DEVELOPMENT REVIEW BOARD
SUPPLEMENTAL SUBMITTAL

PROJECT NO. PR-2021-005597
Application No. SD-2022-00026

RE: PR-2021-005597/ SD-2022-00026 – PRELIMINARY PLAT

PLAT OF
LOTS 1 THRU 10
THE UNIVERSITY OF ALBUQUERQUE
URBAN CENTER
 WITHIN
THE TOWN OF ATRISCO GRANT
 IN
PROJECTED SECTION 2, TOWNSHIP 10 NORTH, RANGE 2 EAST
NEW MEXICO PRINCIPAL MERIDIAN
CITY OF ALBUQUERQUE
BERNALILLO COUNTY, NEW MEXICO
 NOVEMBER, 2021

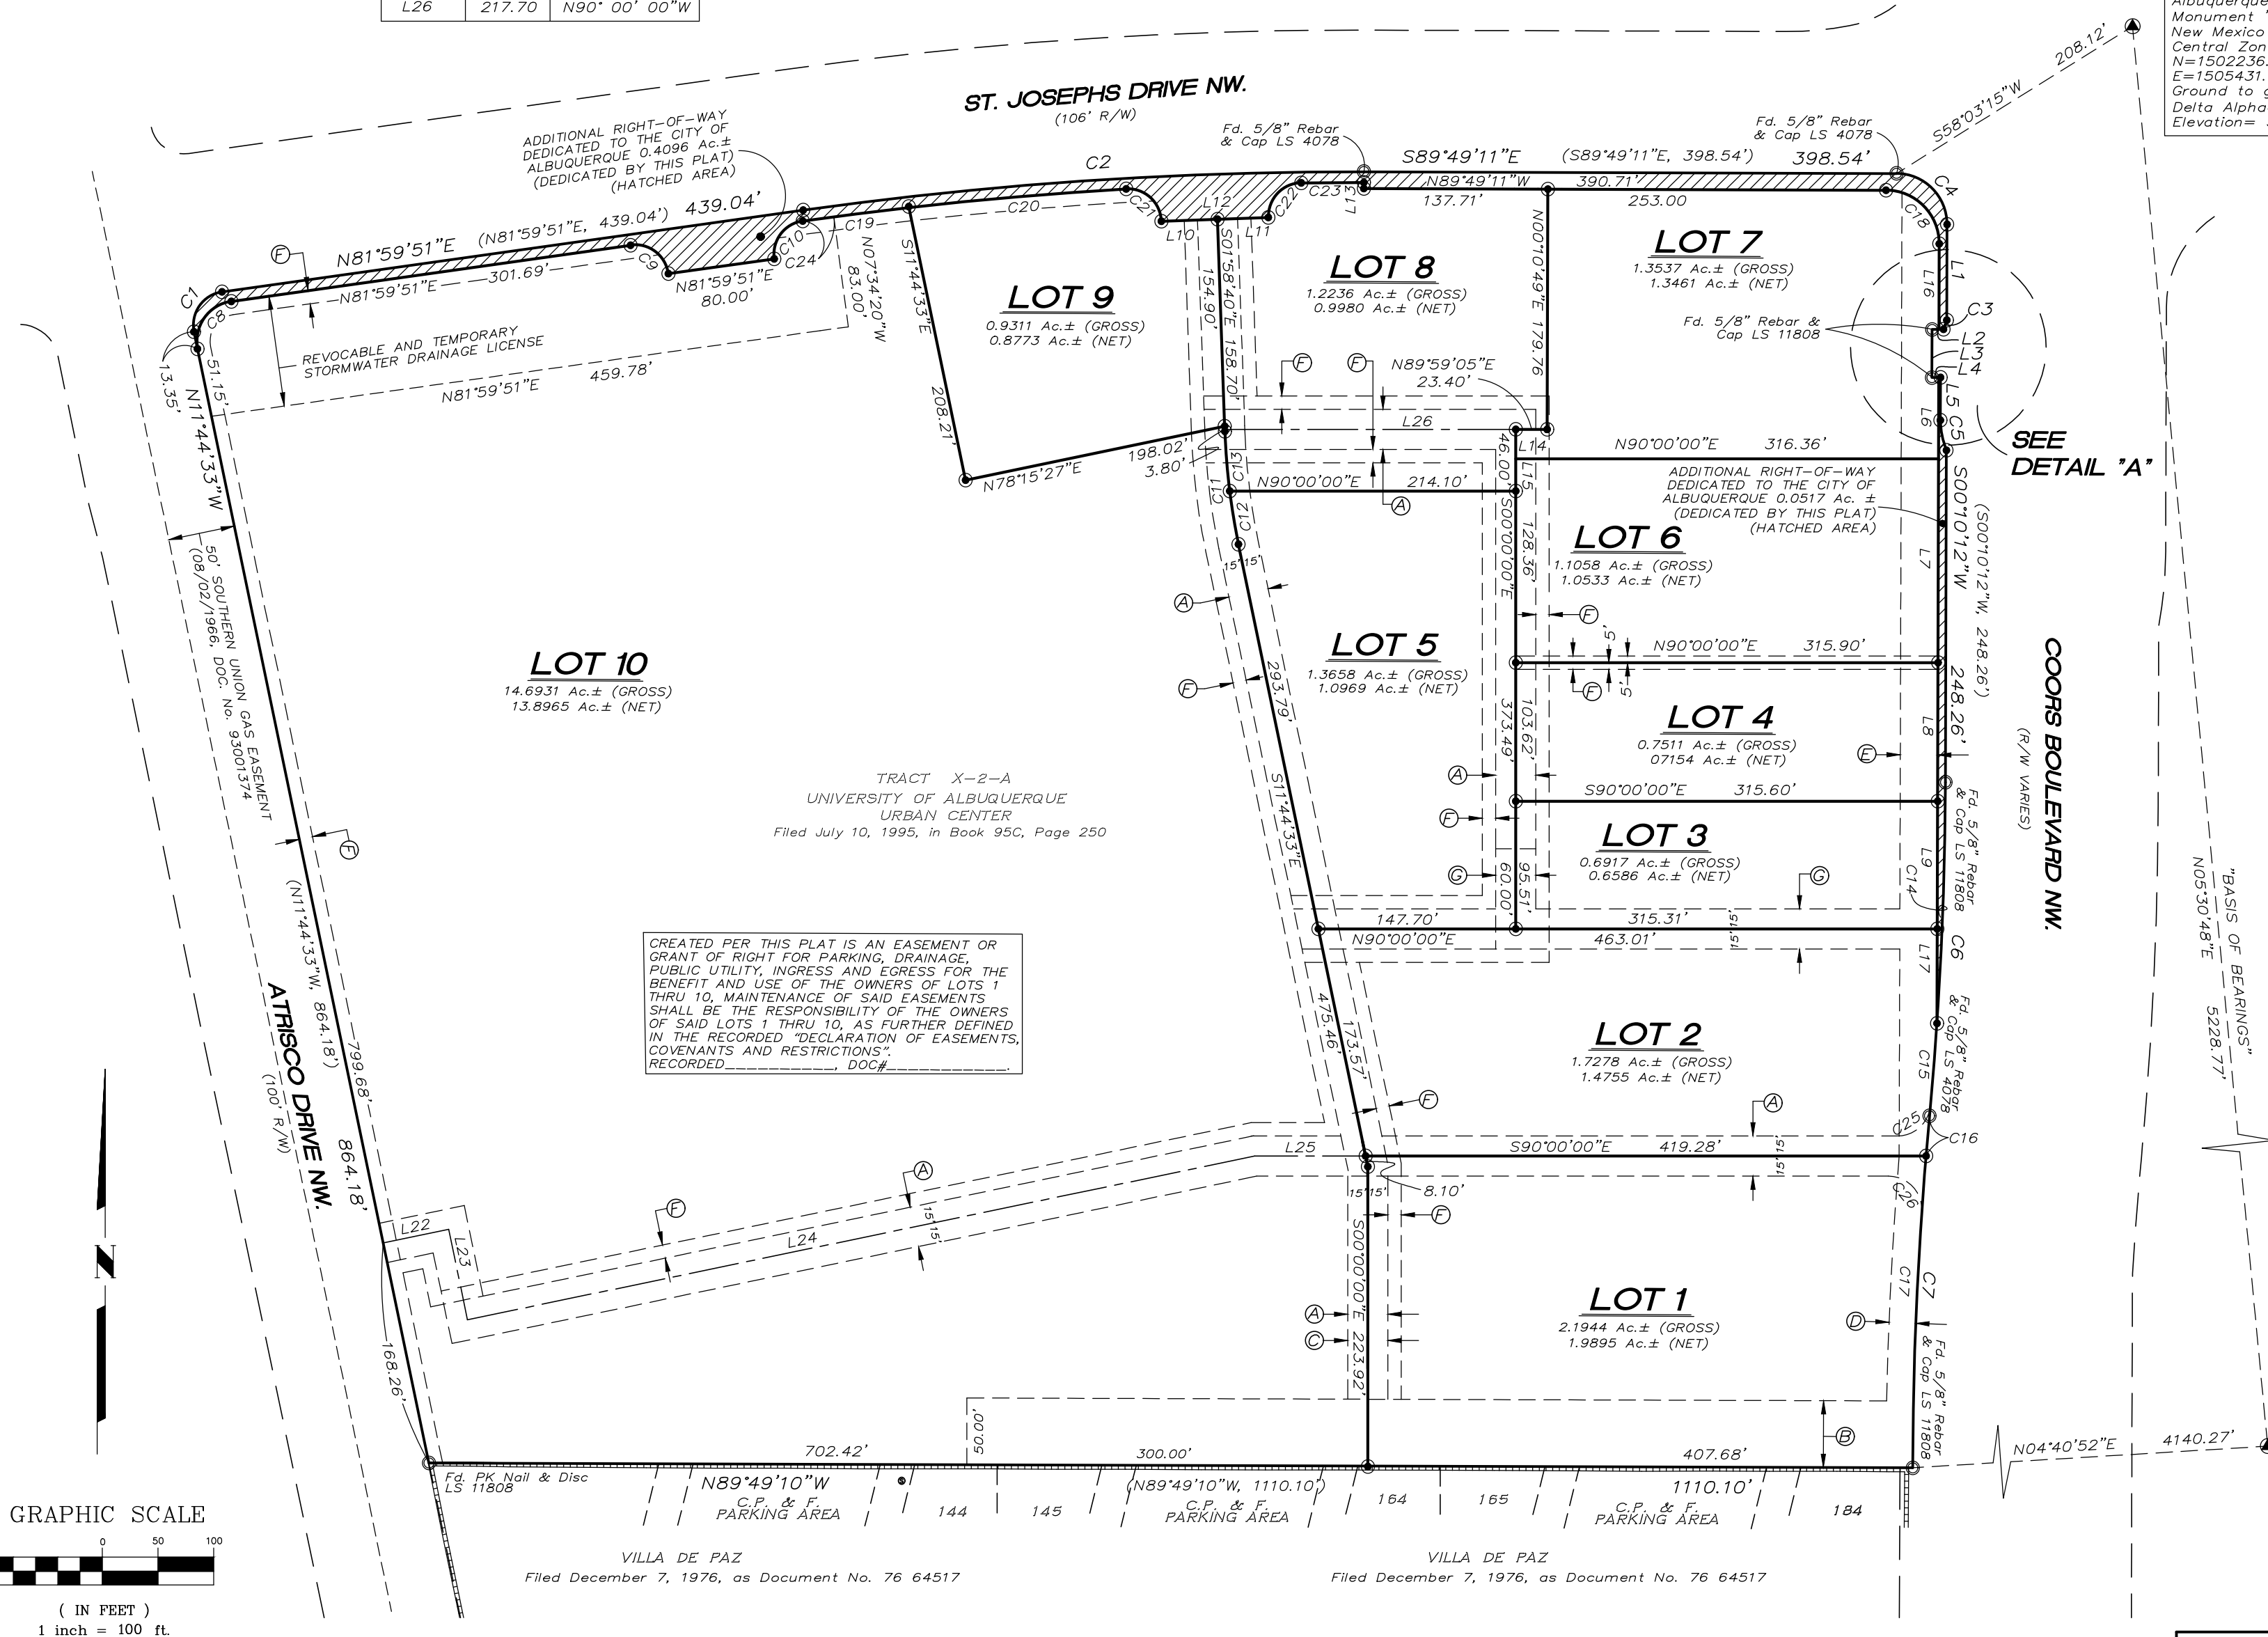
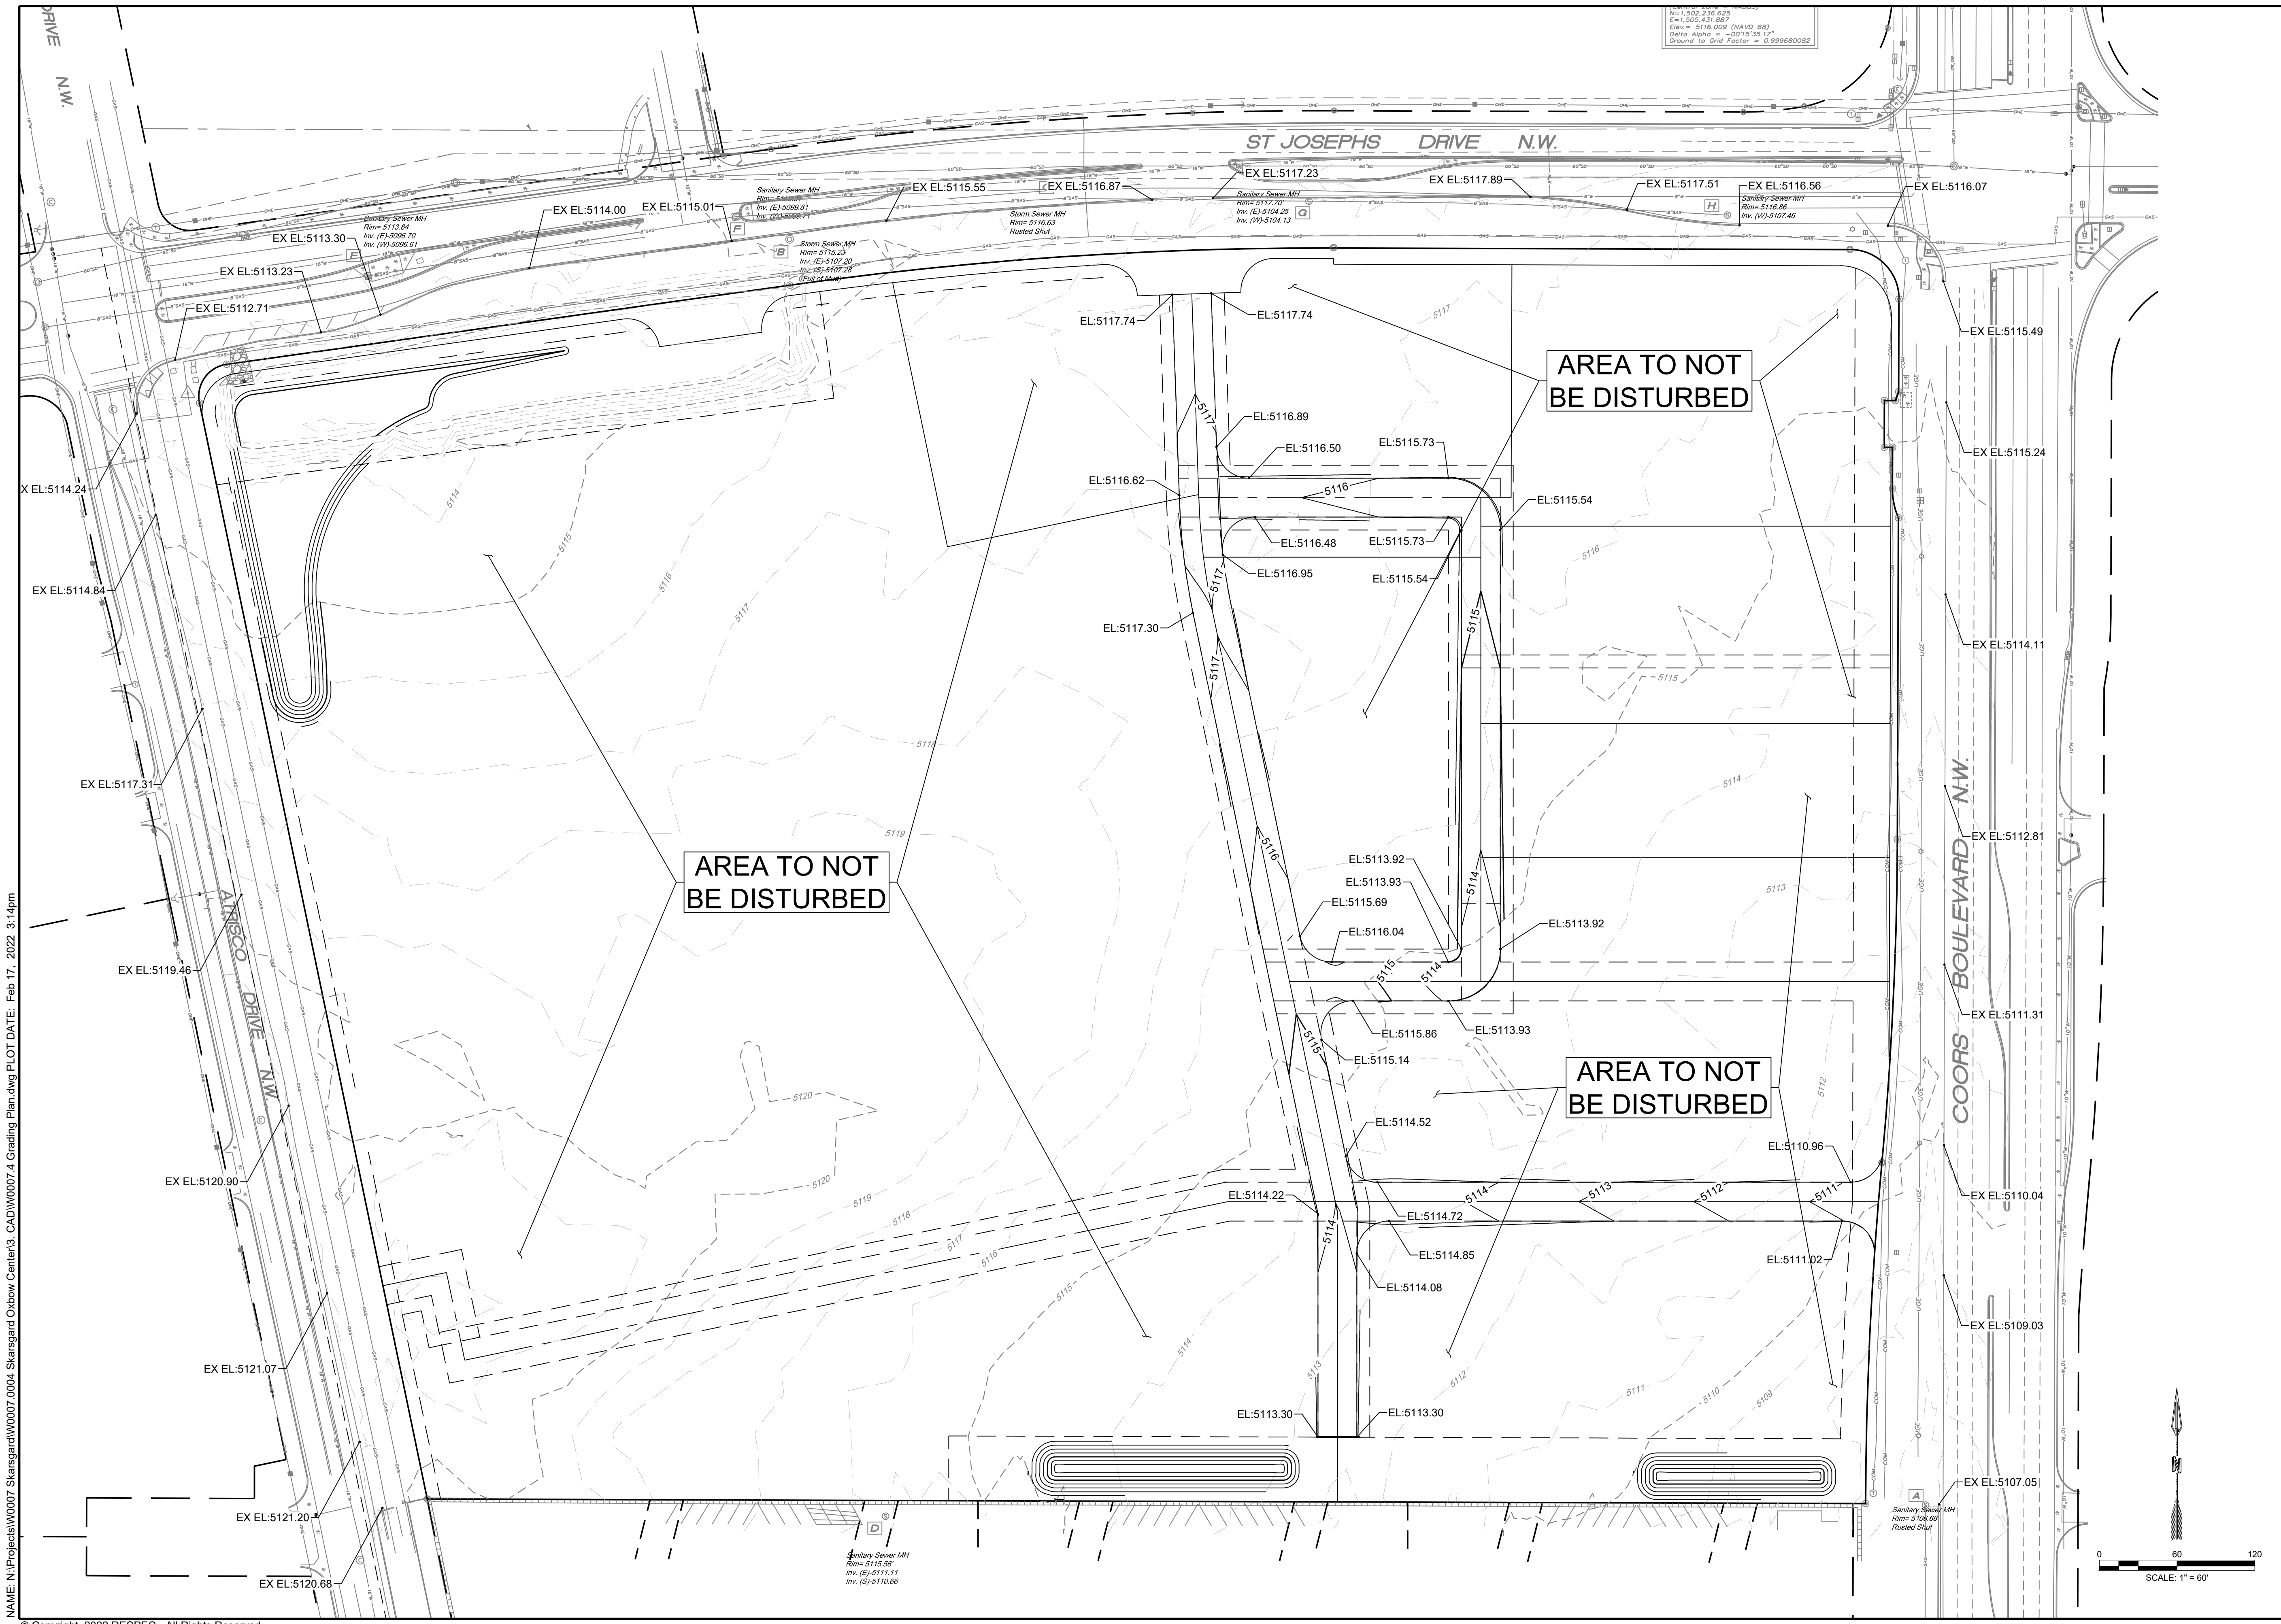
1. G&D approval has been provided.
2. The wording for the existing surge pond at the northwest corner seems wrong for a plat (“Revocable and Temporary stormwater Drainage License”. Based on drainage calculations, a permanent drainage easement needs to be shown on the plat. (Has this comments been addressed).

3. There are several private drainage easements shown on the plat. However, Lot 9 does not currently have an easement going to it. Is this an oversight? Would it be better to just have a Blanket Cross Lot Drainage Easement and sheet drain the lots till you need a specific private detention pond for the lots and private storm pipe outfall connection to the existing 36-in storm drain. (Has this comments been addressed).

1. All easements need to be shown on the Plat.

Applicant Response – G&D approval has been obtained. See approval letter in this resubmittal package. All comments have been address and infrastructure list has been amended.

Applicant Response – All easements are shown on the Plat.
